**Approval of details reserved by condition imposed under ref BN/121/19/PL relating to Condition Nos 3 - surface water drainage, 4 - Construction Management Plan, 5 - materials & finishes, 6 - hard & soft landscaping, 7 - drainage scheme, 8 - storage of waste and 13 - renewable energy.**

**Swallowfield Eastergate Lane Eastergate PO20 3SJ**

The submitted Construction Management Plan (Drawing No. 2019.257MAN dated May 2020) has been checked by West Sussex Highways.

drawing no.
2019.257MAN

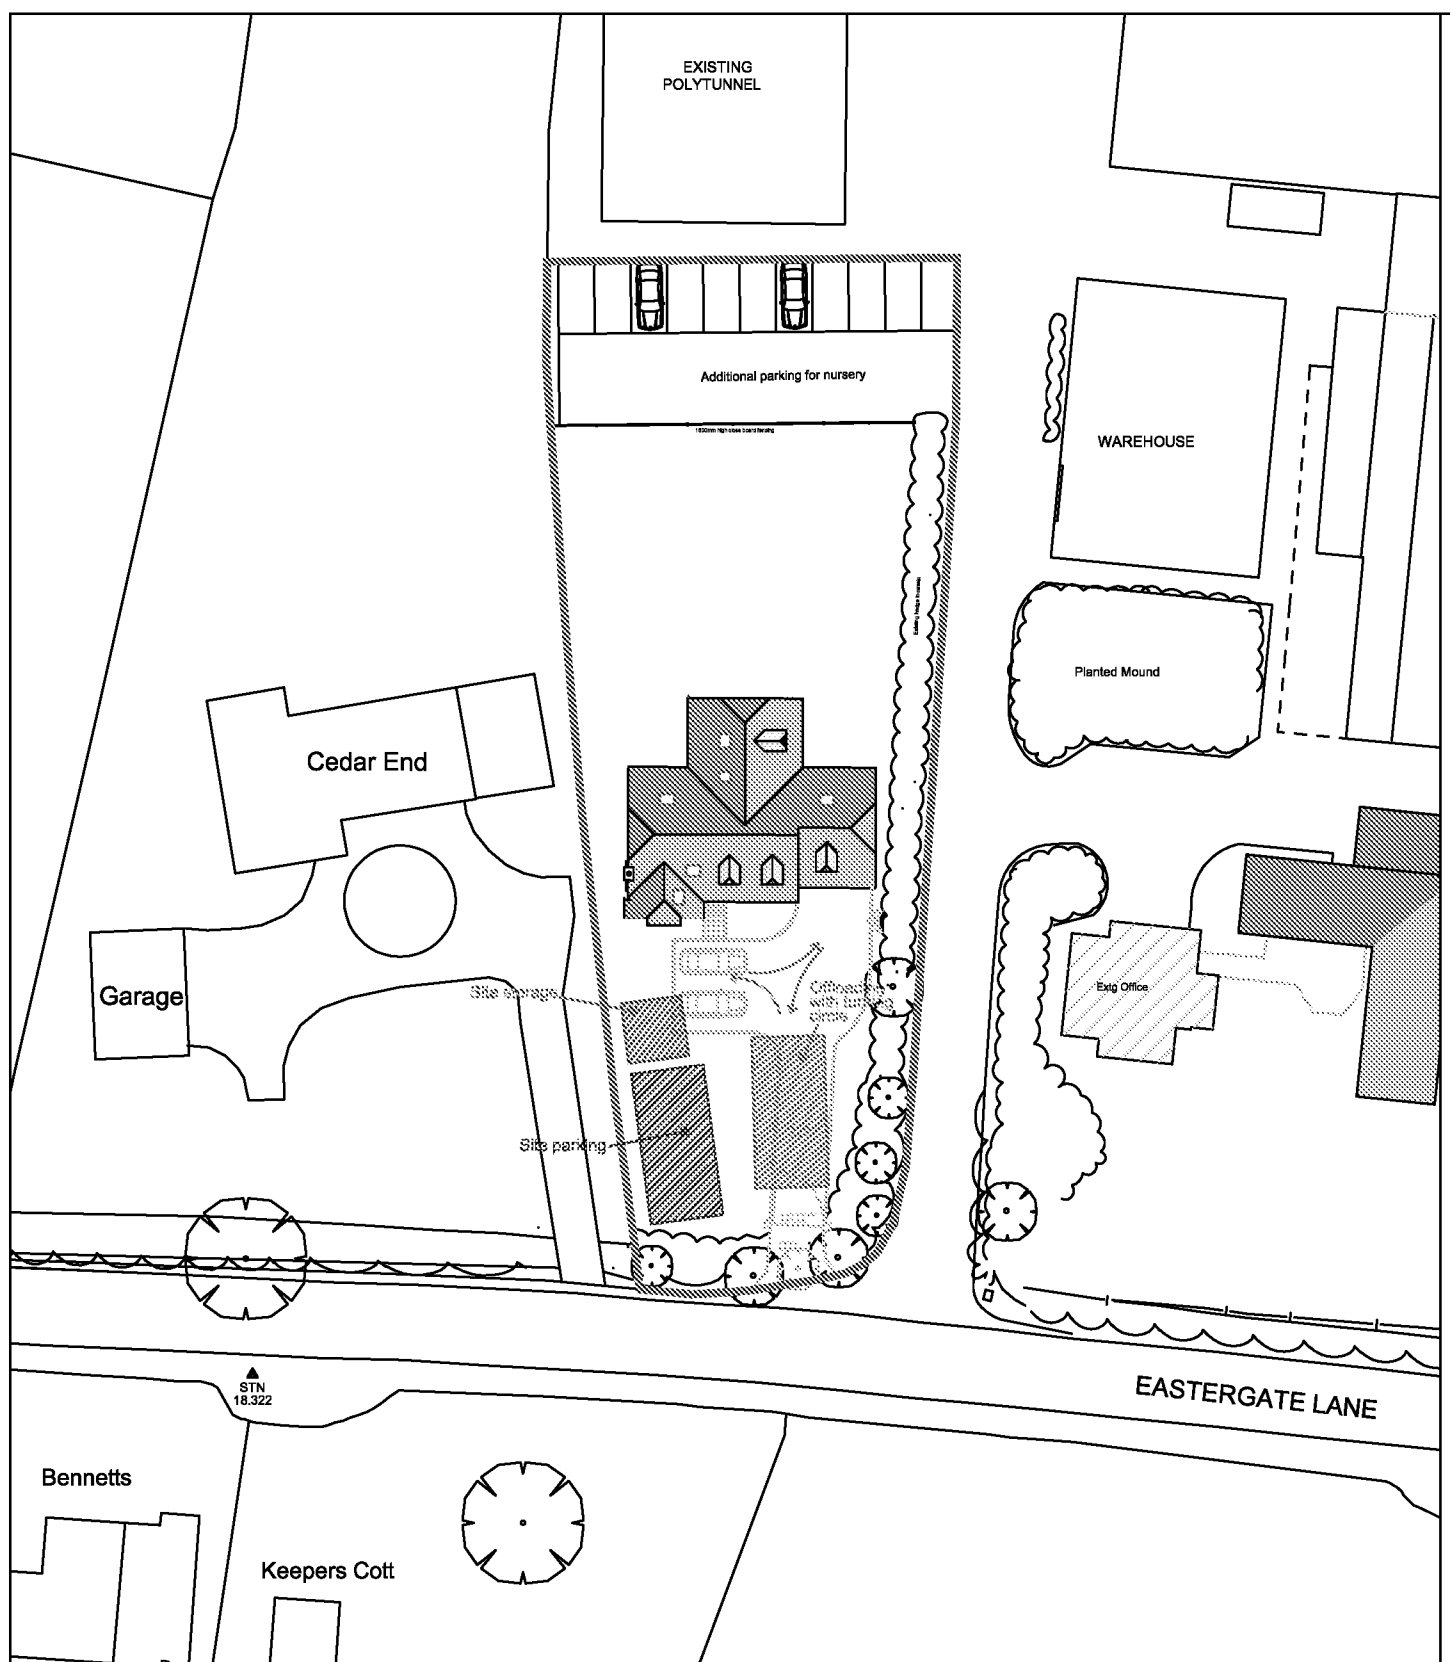
E A designated area for contractor parking on-site has been demonstrated on the site plan.

F A designated area for loading and unloading on-site has been demonstrated on the site plan.

G A designated area for storage of plant and materials on-site has been demonstrated on the site plan.

H The CMP Statement states that hoarding fencing will be erected in the necessary places.

I The CMP Statement states that wheel washing facilities will not be required due to the presence of tarmac at the site. The LHA considers this acceptable.
